**re: Geotechnical Review – Grading and Site Servicing Plan Review
Proposed Residential Building
1146 Snow Street, Ottawa**

date: January 20, 2026

file: PG7295-MEMO.03

DRAWING TITLE: BUILDING SECTIONS

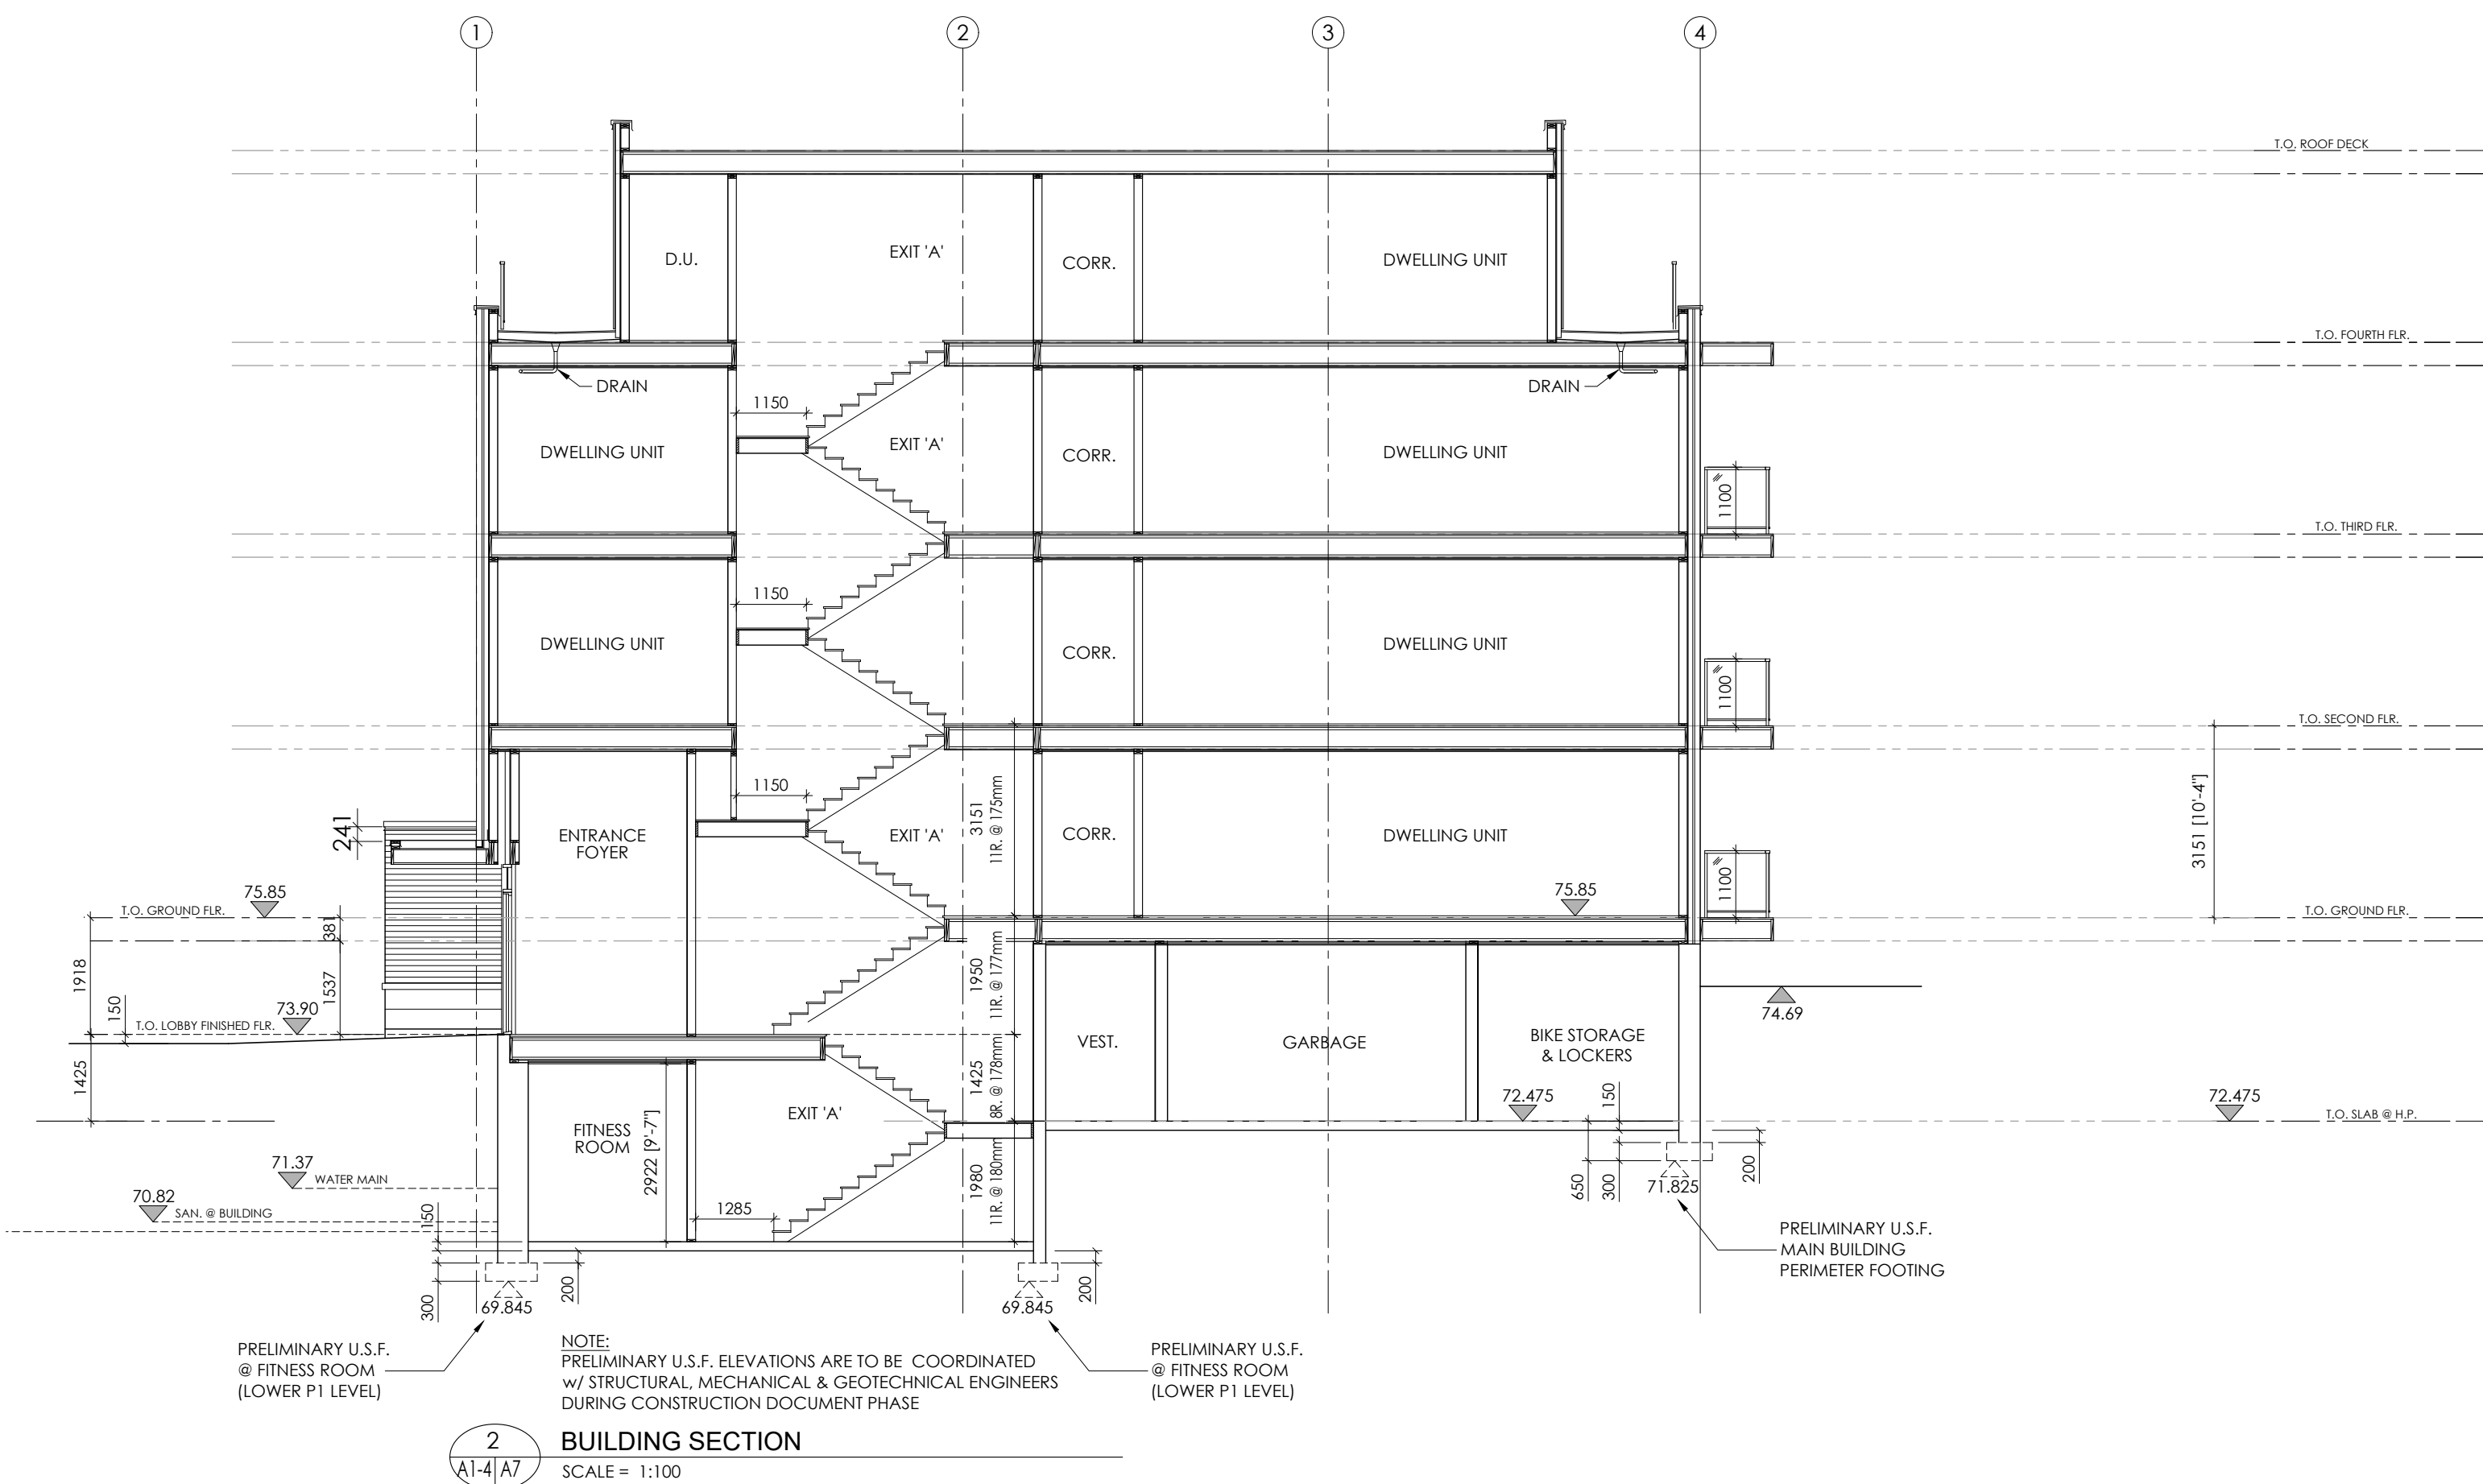
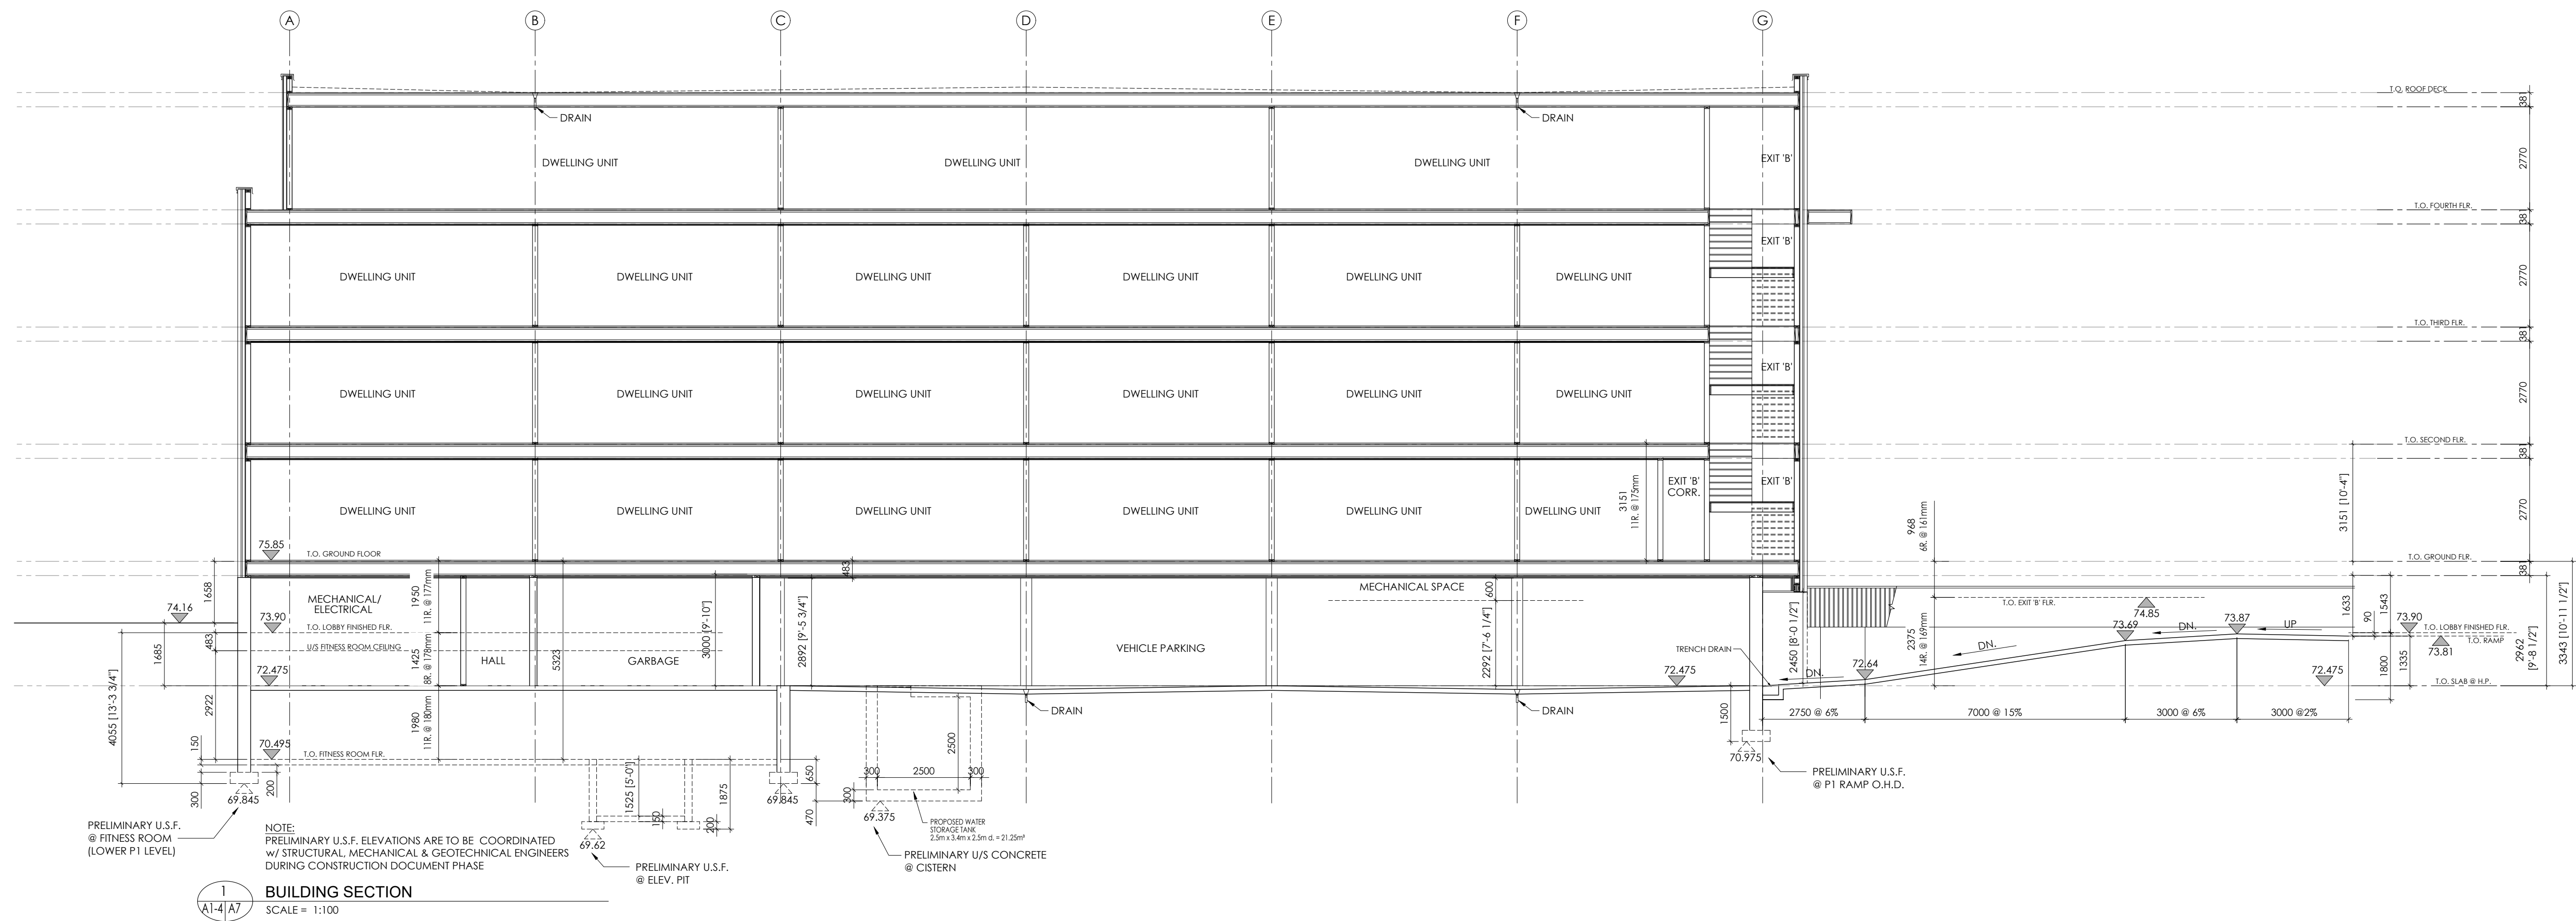
Based on our review of the above referenced architectural drawings – Project No. 19361-Drawings A1 to A7, Revision 3, dated November 12, 2025, the USF elevations of the building will vary between 69.845 m to 70.975 m and the USF elevation for the elevator shaft will be located at 69.62 m.

The underground basement level as well as the fitness room level are expected to be heated. Thus, perimeter footings of the underground basement structures are required to be insulated against the deleterious effects of frost action. A minimum of 1.5 m of soil cover alone, or a minimum of 0.6 m of soil cover, in conjunction with adequate foundation insulation, should be provided. Based on our review of the above-referenced architectural drawings, all the building footings were noted to have a minimum 1.5 m of soil cover.
